**Subject:** 3/2013/1060 - Construction of part two storey, part single storey side extension for residential accommodation  
- 70a Downham Road, Chatburn BB7 4AU

**Planning Application Reference: 3/2013/1060**

**Proposal: Construction of part two storey, part single storey side extension for residential accommodation.**

**Location: 70a Downham Road, Chatburn BB7 4AU**

Proposed Site Plan - 1:500

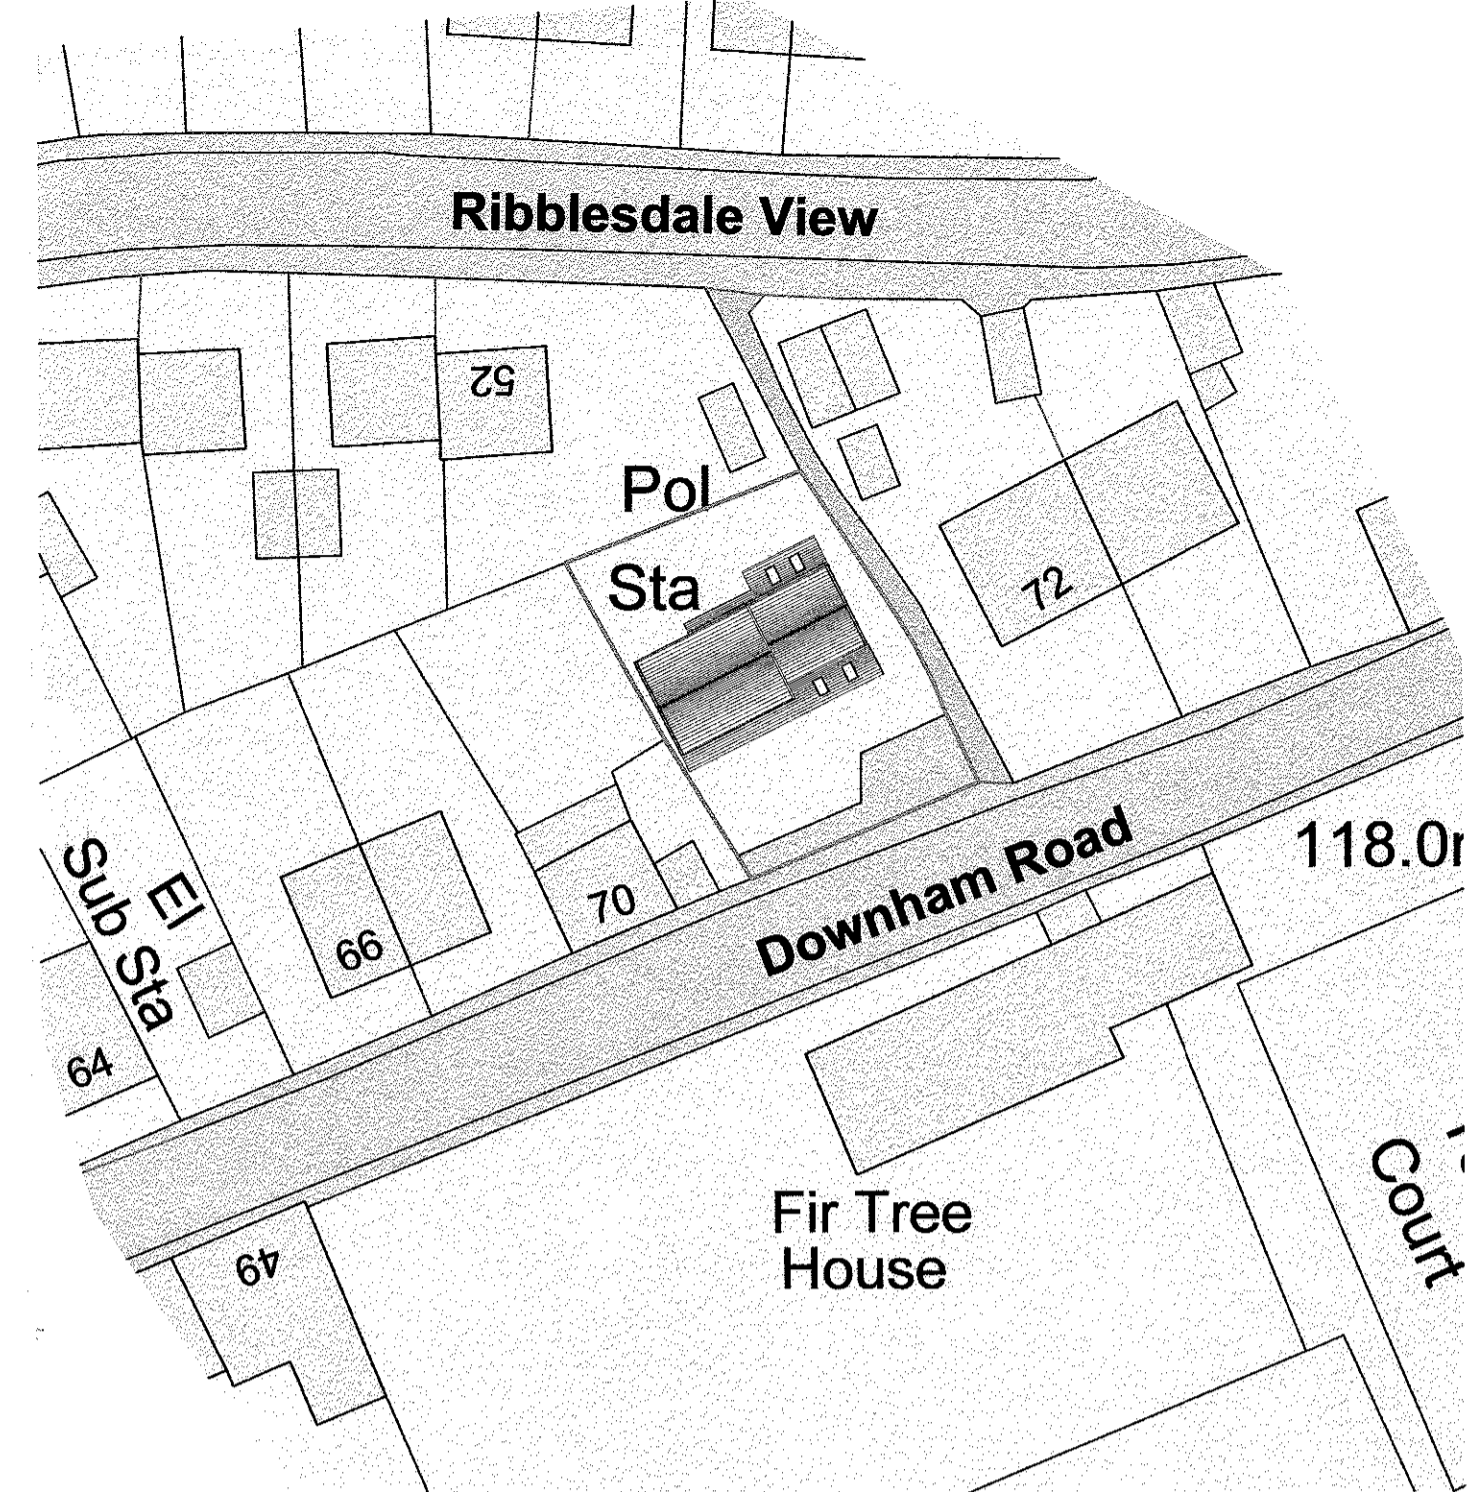
Currently there are three bedrooms in the dwelling. With the proposed development there will be four bedrooms to use in the dwelling. According to JLSP residential parking standard guidelines, 3 bedroom dwelling will require 2 no parking spaces and 4 bedroom dwelling will require 3 no parking spaces within curtilage of the property. With an existing garage and drive way, there is possibility of parking two vehicles within the curtilage of the property. With the proposed development there will be a requirement of three parking spaces. Since there are only two parking spaces within curtilage of the property, additional parking space will be required to be created within curtilage of the property to accommodate total of three vehicles.

In principle there is no objection to the proposed development. Following condition shall be attached with the planning approval notice.

1no additional parking shall be provided to accommodate total three vehicles within curtilage of the property.
